Letter No. B3/16033/97

Sub: CMDA - APU - PP - proposed constr. of G+3F Resl. bldg
for 108 D. units at Justice Ratanavel Pandian Road in
S. Nos. 339/2, 348/2, 345/1c, 345/1d and 345/1B, A2
of Mosayyan village - Permittance of D.C and S.D. Road.

The Planning Permission Application and Revised Plan
received in the reference first cited for the proposed constr. of
G+3F Resl. bldg. blocks for 108 D. units at Justice Ratanavel Pandian
Road in S. Nos. 339/2, 348/2, 345/1c, 345/1d, and 345/1B, A2 of Mosayyan
is under scrutiny. To process the application further, you
are requested to remit the following by seven separate
Demand Drafts of a Nationalised Bank in Chennai City drawn in
favour of Member-Secretary, CMDA, Chennai-8 at Cash Counter
(between 10.00 A.M. and 4.00 P.M) in CMDA and produce the
duplicate receipt to the Area Plans Unit 'B' Channel, Area
Plans Unit in CMDA.

SITE PLAN  
SCALE 1:200

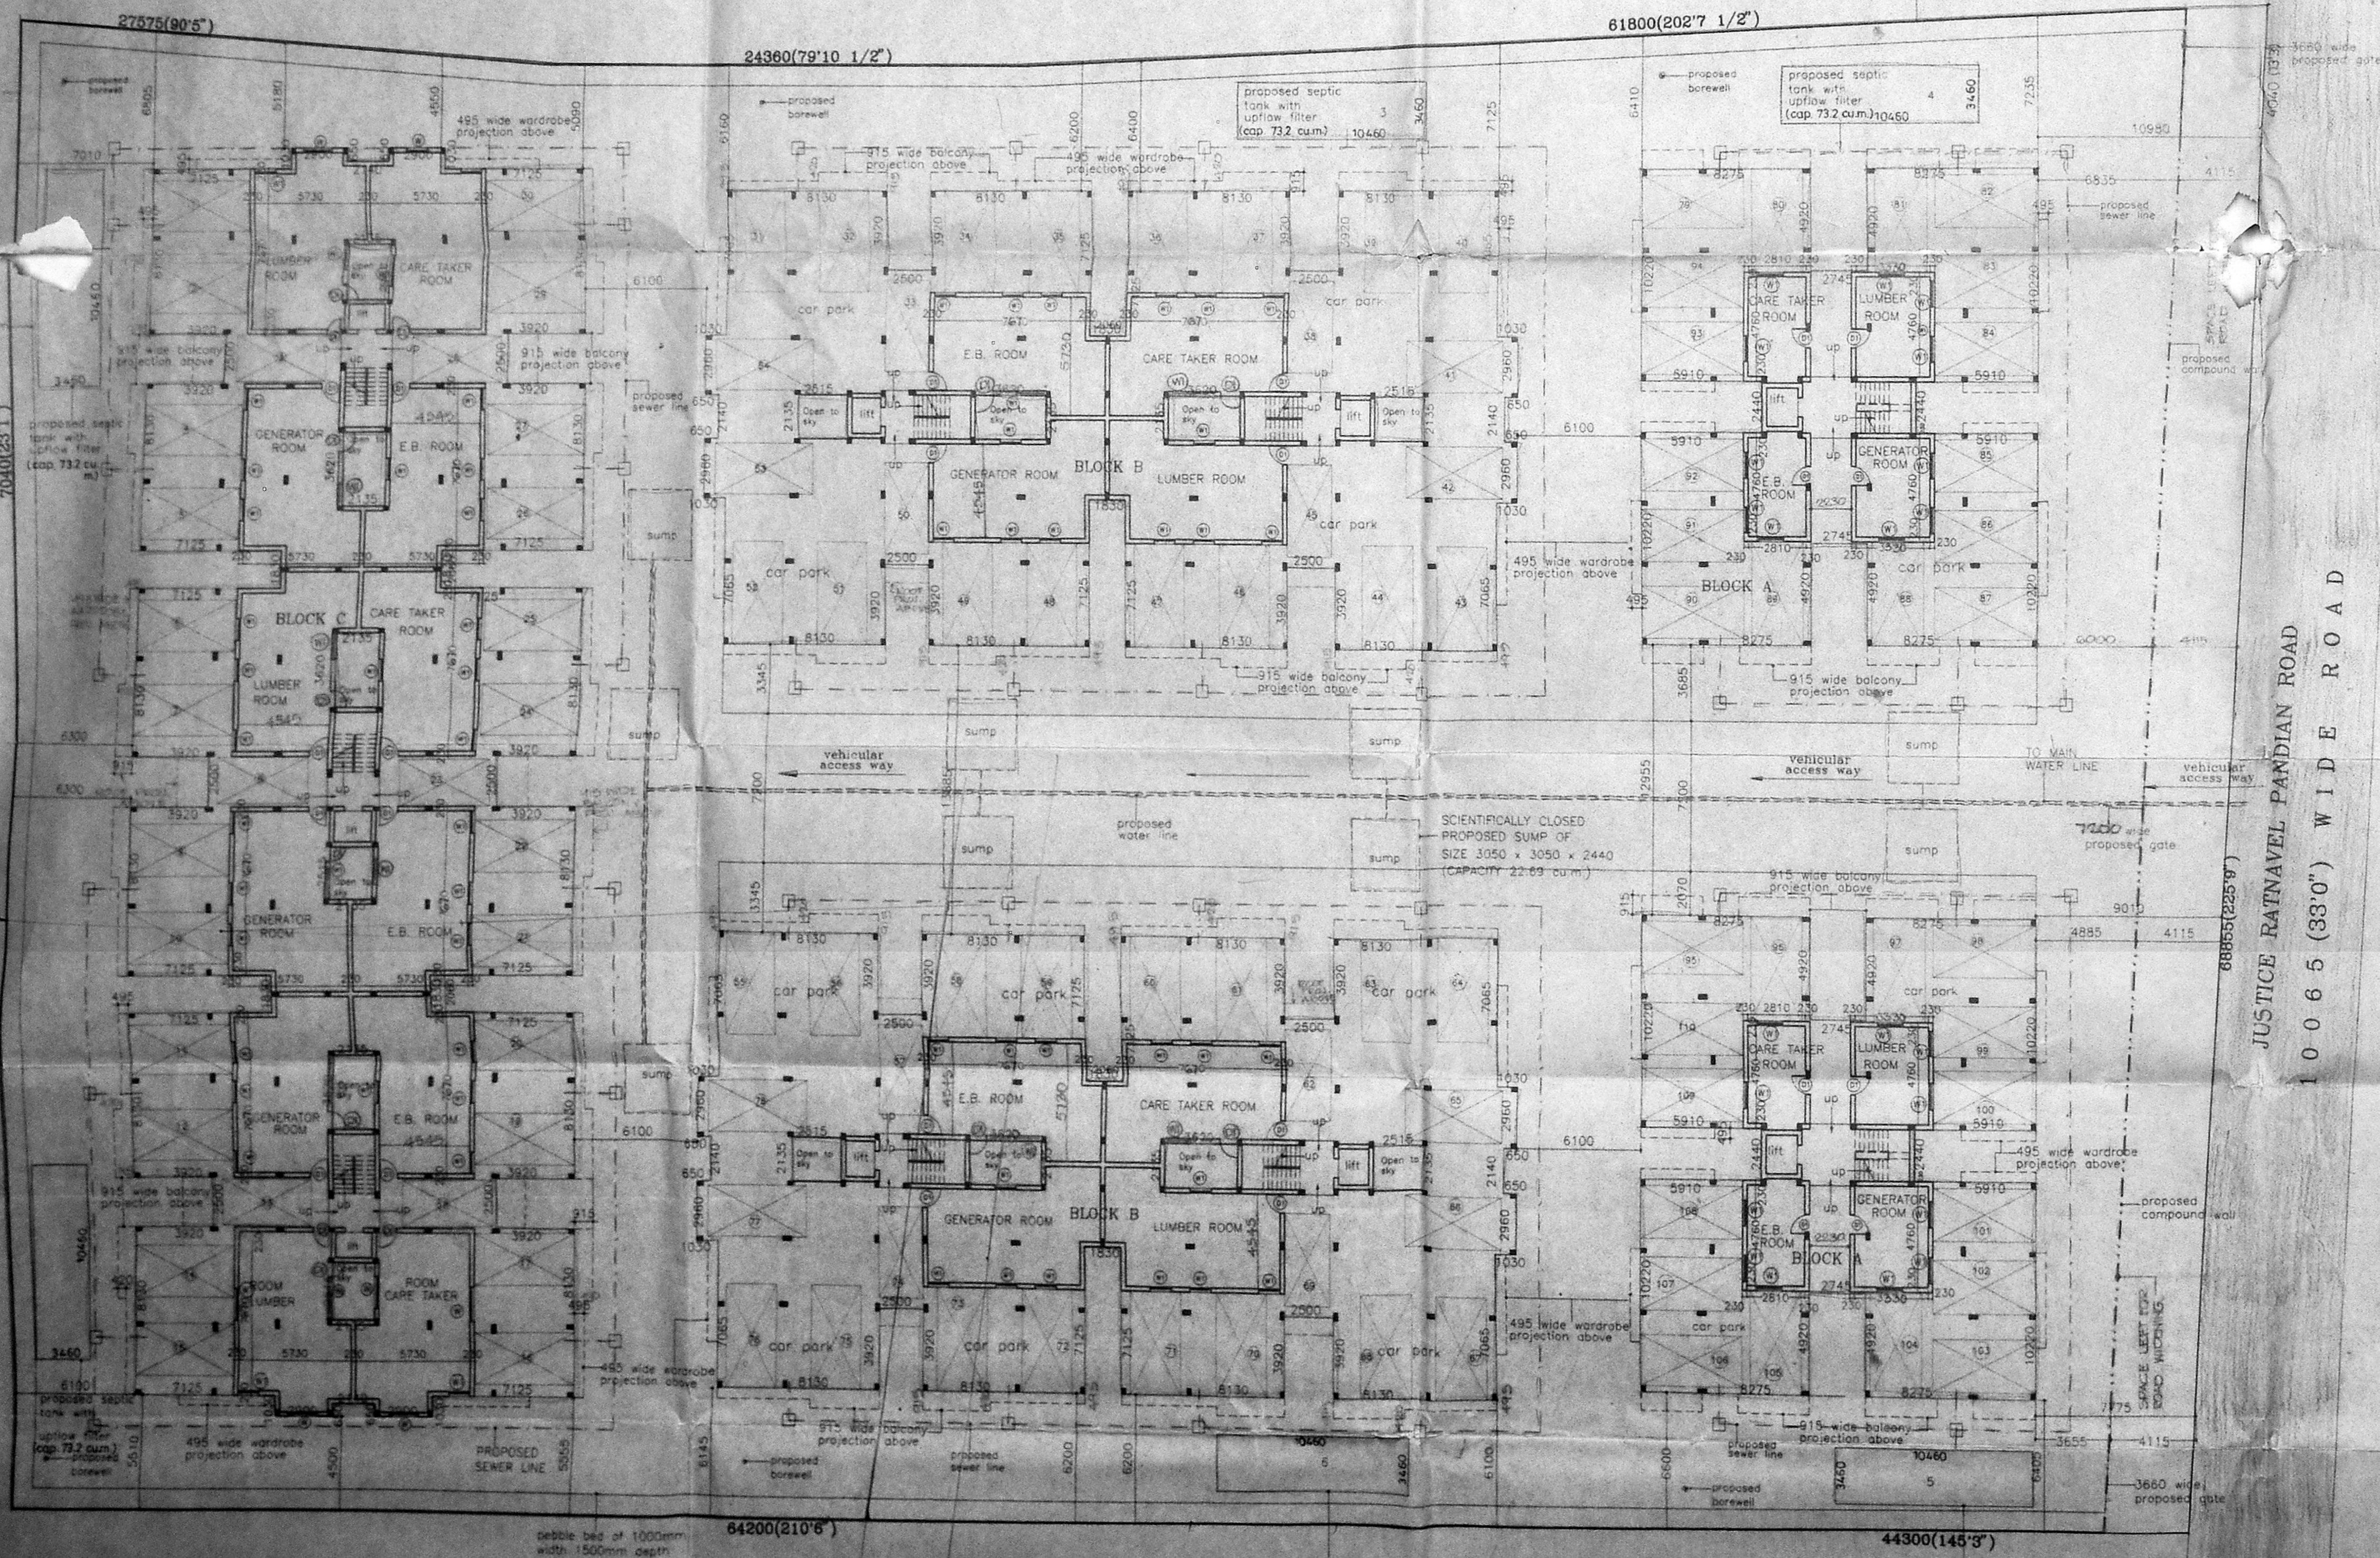
① you are also reqd. to furnish 5 sets of R.P complying with the following requirements:-
 i) All Architectural projections to be limited to 0.60m (against 0.61m)
 ii) Size of septic tank to be incorporated in site plan and
 iii) Measurement of site on North east corner to be indicated in site plan as per FMB (Circular 13/87) of 30/12/97
 Yours faithfully,
 M.S.G
